Appeal reference APP/R5510/W/19/3220503
Stanford House, 9 Nestles Avenue, Hillingdon
Addendum Statement of Common Ground in relation to Amenity Space

title
**Fifth Floor Plan
As Proposed**

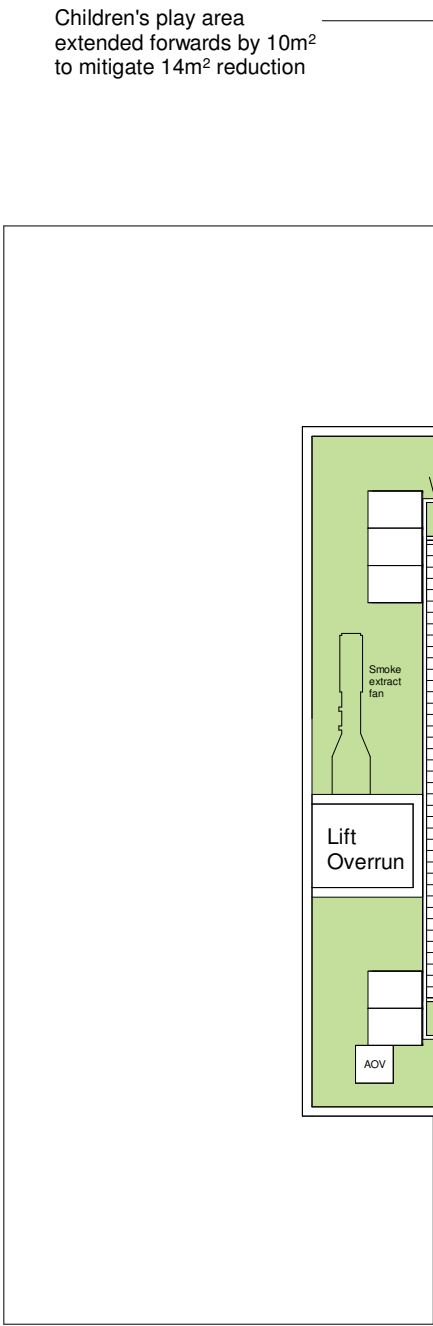
Plan Title	Original plan reference	Revised plan reference
4th floor	1104E	1104F
5th floor	1105E	1105F
8th floor	1108D	1108E
Southern elevation	1301B	1301C

- (i) the relationship between the communal amenity space provided on the 4th, 5th and 8th floors and the immediately adjacent residential units (unit 4.1 on the 4th floor, units 5.1 and 5.7 on the 5th floor and units 8.1 and 8.4 on the 8th floor);

- (ii) the relationship between the communal amenity space provided on the 5th floor and the balconies to units 6.1 and 6.8 on the 6th floor; and
 - (iii) the relationship between the communal amenity space provided on the 8th floor and the balconies to units 9.1 and 9.4 on the 9th floor.

2. The parties agree that the introduction of the revised plans would not prejudice any interested party.
3. On the basis that the appeal is to be determined on the basis of the revised plans the Council withdraws its objections to the scheme (as set out in Mr Volley's proof paragraphs 11.23 – 11.27) in relation to:
